Consultation Response from KC Highways Development Management

2026/90564 Briar Mead, Pinfold Lane, Mirfield, WF14 9JA

Demolition of existing garage and erection of replacement single storey extension with link to rear of existing dwelling

PROJECT TITLE BRIAR MEAD			
DRAWING TITLE BLOCK PLAN			
SCALE 1:500	DRAWN EG	CHECKED JH	PROJECT REFERENCE ODS 26/116
PAPER SIZE A3	DWG NUMBER (20)002	DATE 26/01/25	REVISION /
CLIENT MR & MRS GORDON

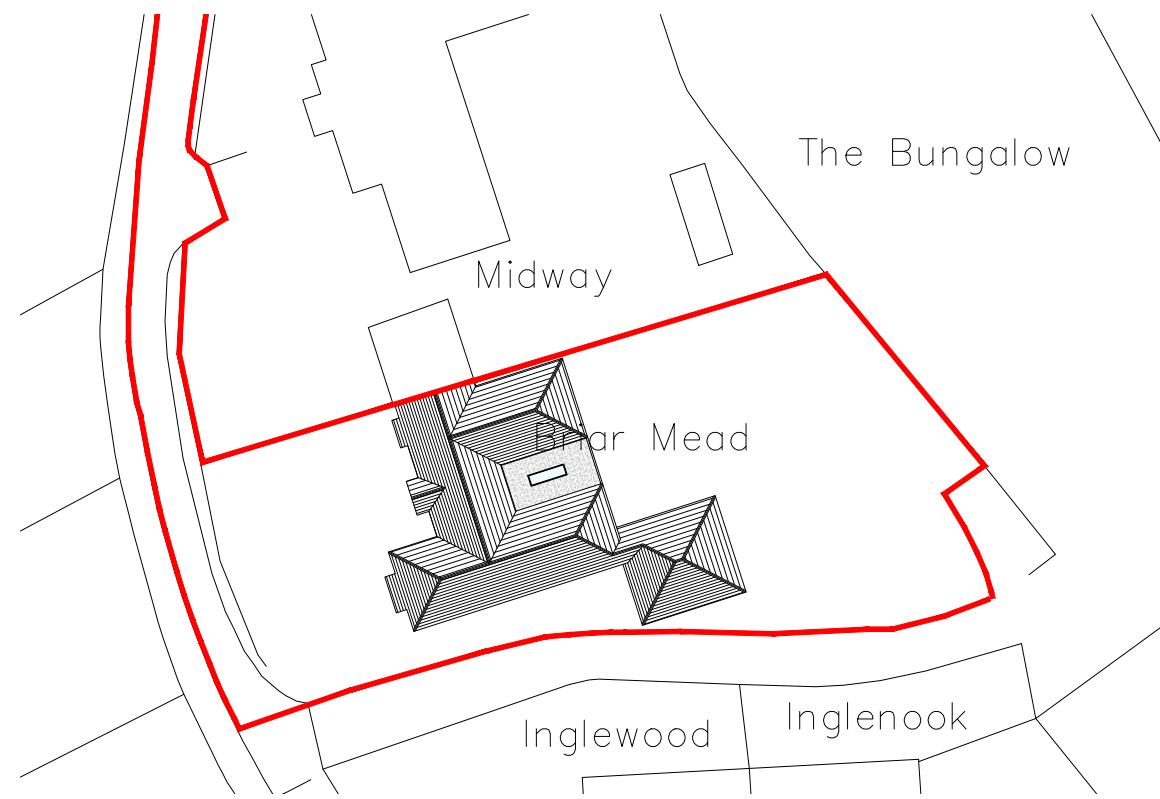
Whilst the proposals remove the garage parking, it is considered that the existing driveway provides at least three off-street car parking spaces.

There are no amendments to the existing access arrangements as a result of the proposals, access continues to be taken from a private road that connects at its northern end to Pinfold Lane.
